## Schedule of updated planning drawings and reports following amendments to facilitate Ball Strike Netting and other minor alterations

DRAWING NUMBER: 22315-ALA-00-XX-DR-L-0012	STATUS: S2	REVISION: P02
---	----------------------	-------------------------

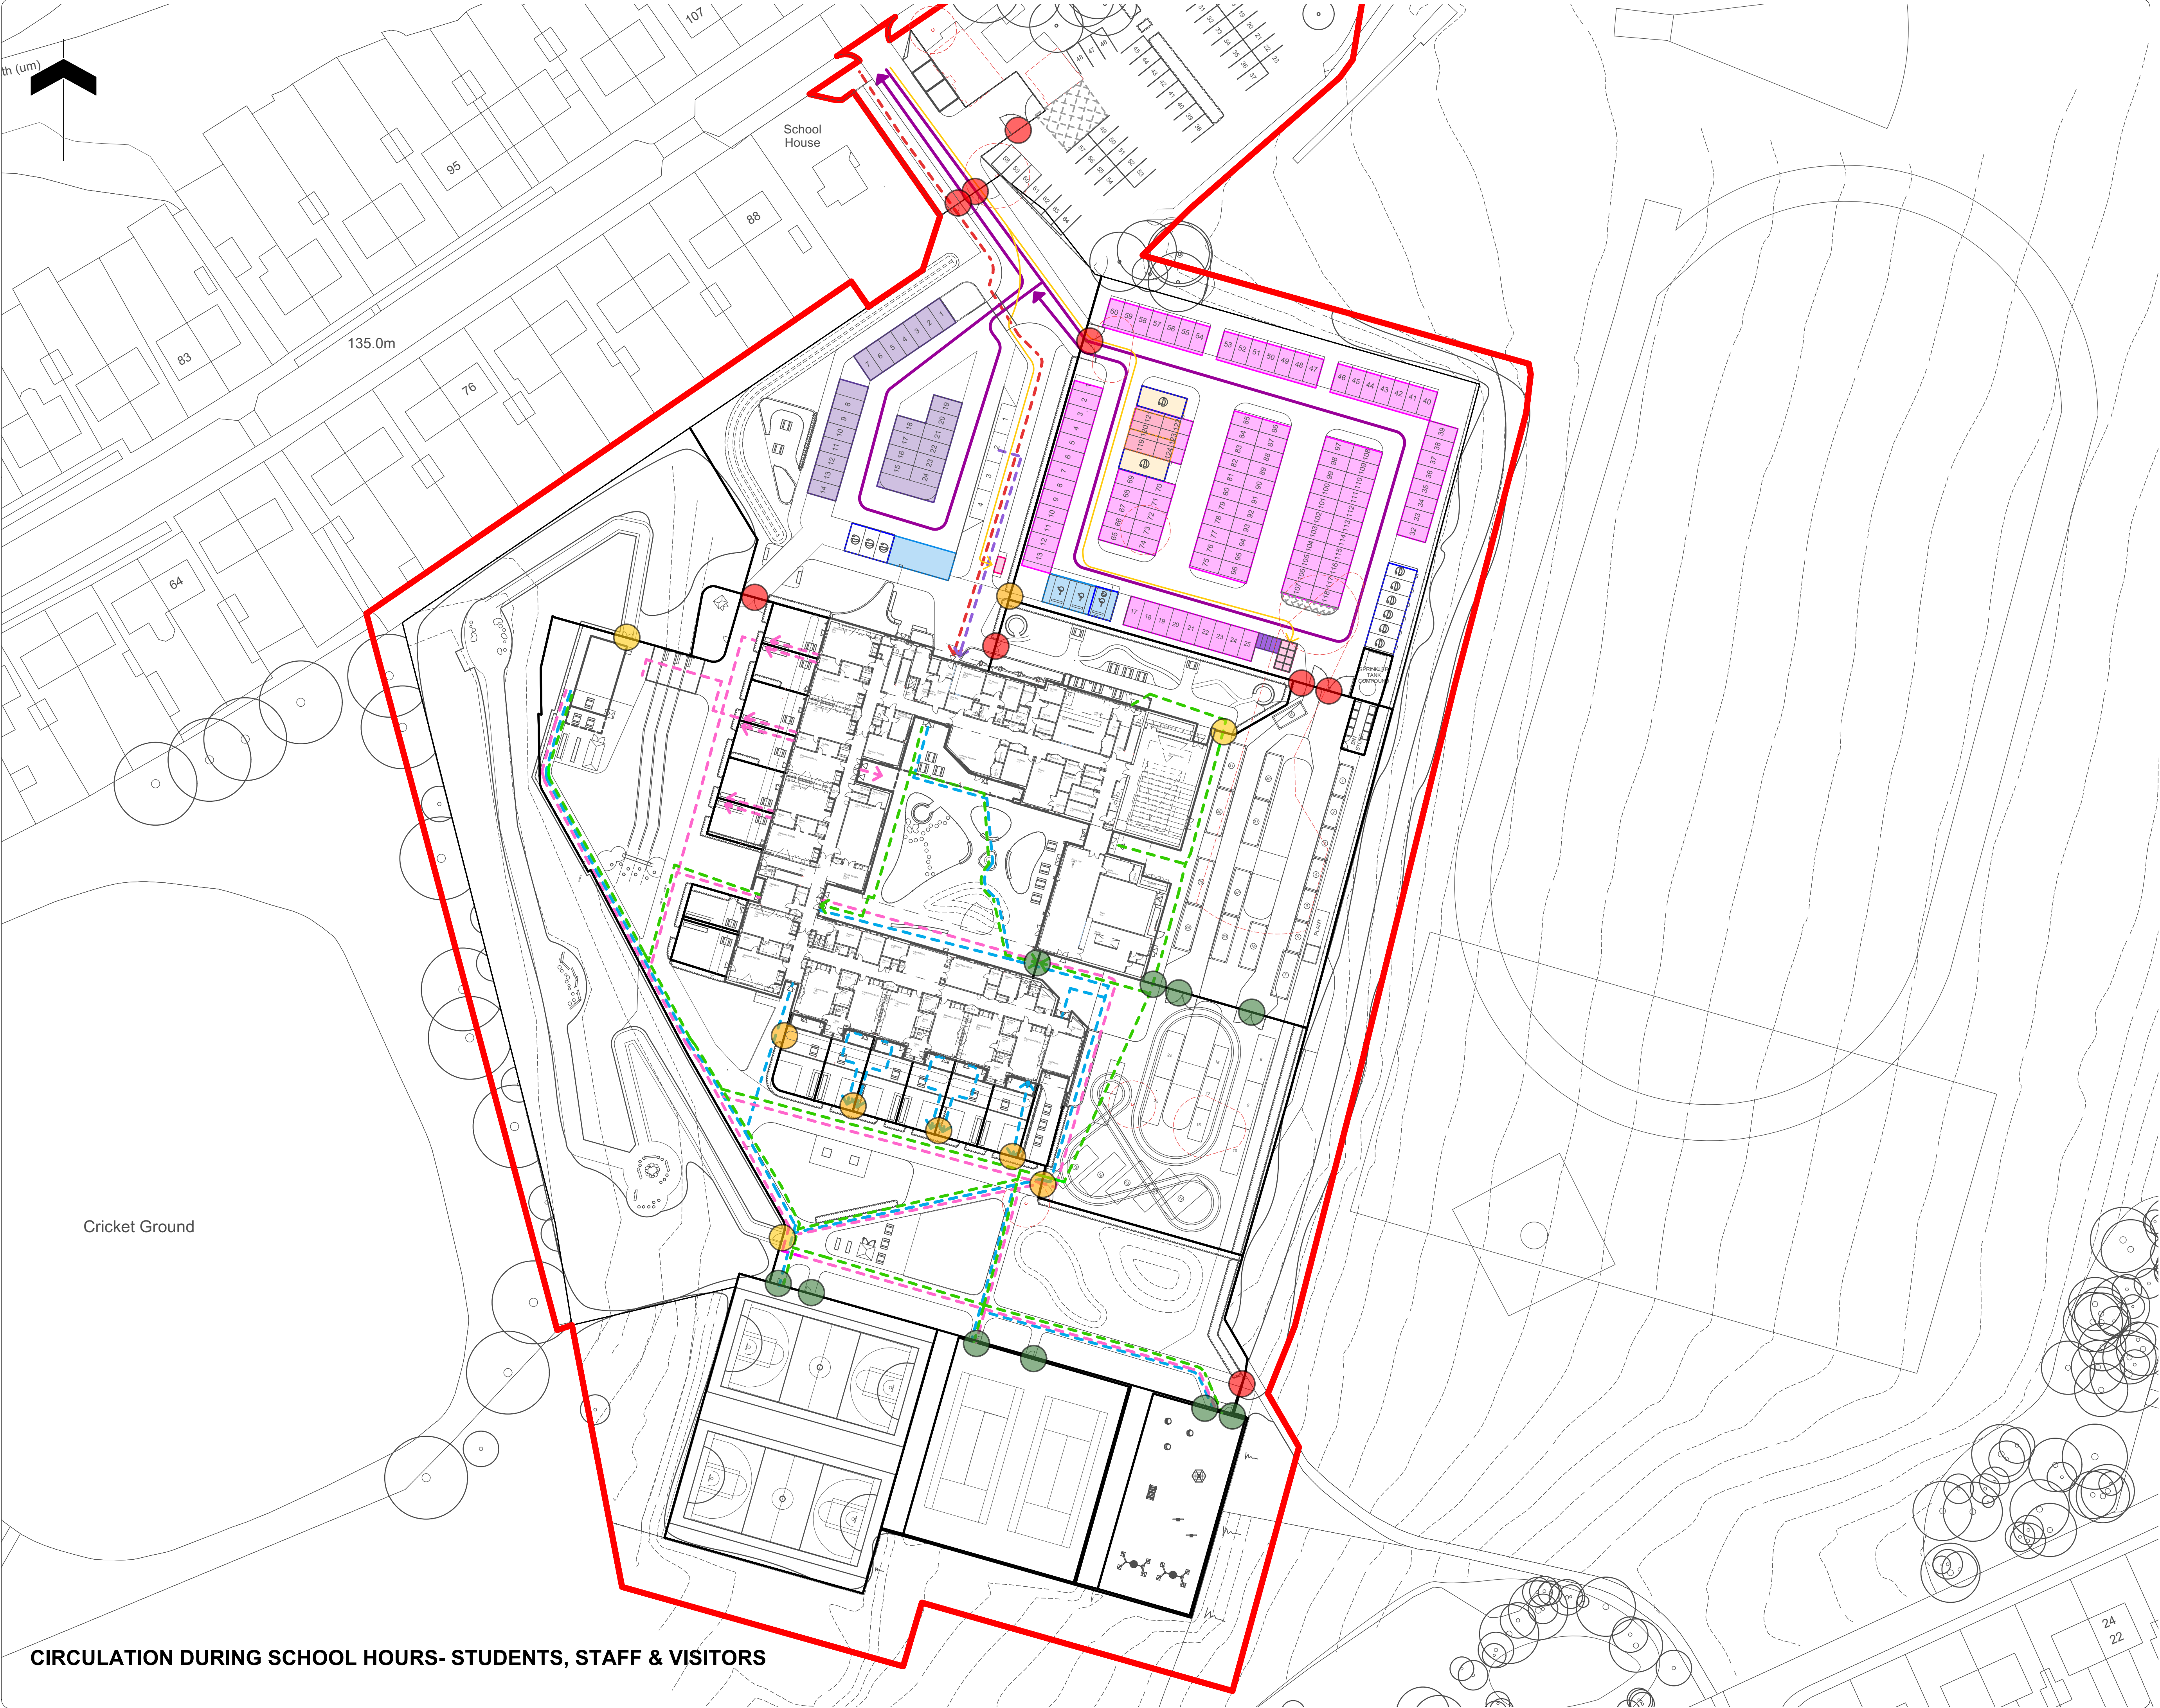
Access and Circulation Plans -Service and Maintenance -During the School Day -Arrival and Departure Students	22315-ALA-00-XX-DR-L-0010 rev. P02 22315-ALA-00-XX-DR-L-0012 rev. P02 22315-ALA-00-XX-DR-L-0021 rev. P03	22315-ALA-00-XX-DR-L-0010 rev. P04 22315-ALA-00-XX-DR-L-0012 rev. P04 22315-ALA-00-XX-DR-L-0021 rev. P05	Re-issued for planning following Sport England objection withdrawal. Changes as follows: 1. Updated to align with changes to GA. 2. Vehicle entrance barrier indicated on diagram.
EVCP Provision Plan	22315-ALA-00-XX-DR-L-0033 rev. P01	22315-ALA-00-XX-DR-L-0033 rev. P06	Re-issued for planning following Sport England objection withdrawal. Changes as follows: 1. Updated to align with changes to GA.
Waste Management Plan	22315-ALA-00-XX-DR-L-0034 rev. P01	22315-ALA-00-XX-DR-L-0034 rev. P06	Re-issued for planning following Sport England objection withdrawal. Changes as follows: 1. Updated to align with changes to GA.

Plan	Reference	Updated drawing	Description of amendments
			2.Binstore layout revised.
Urban Green Space	22315-ALA-00-XX-DR-L-0035 rev. P01	22315-ALA-00-XX-DR-L-0035 rev. P03	Re-issued for planning following Sport England objection withdrawal. Changes as follows: 1.Updated to align with changes to GA.
Sequential Axonometric	WSC-FSA-XX-XX-DR-A-7010 rev. P05	No revision	No revision
Street Scene Plan	WSC-FSA-XX-XX-DR-A-7020	No revision	No revision
Proposed Drainage Layout	22315-BWB-XX-XX-D-C-0500 rev. P03	No revision	No revision
External Lighting Plan	22315-AGL-24-XX-D-E-0001 rev. P06	No revision	No revision
Planning and Legal Completion Boundary Plan	22315-ALA-00-XX-DR-L-0038 P01	No revision	No revision
Ball Stop Netting Layout	22315-ALA-00-XX-DR-L-0049_P02	(previously submitted on 23.01.25)	Details of proposed ball stop netting to meet Sports England requirement
<b>New Plan</b> - Ball Stop Netting Detail	n/a	22315-ALA-ZZ-ZZ-D-L-1034_P03	Details of proposed ball stop netting to meet Sports England requirement
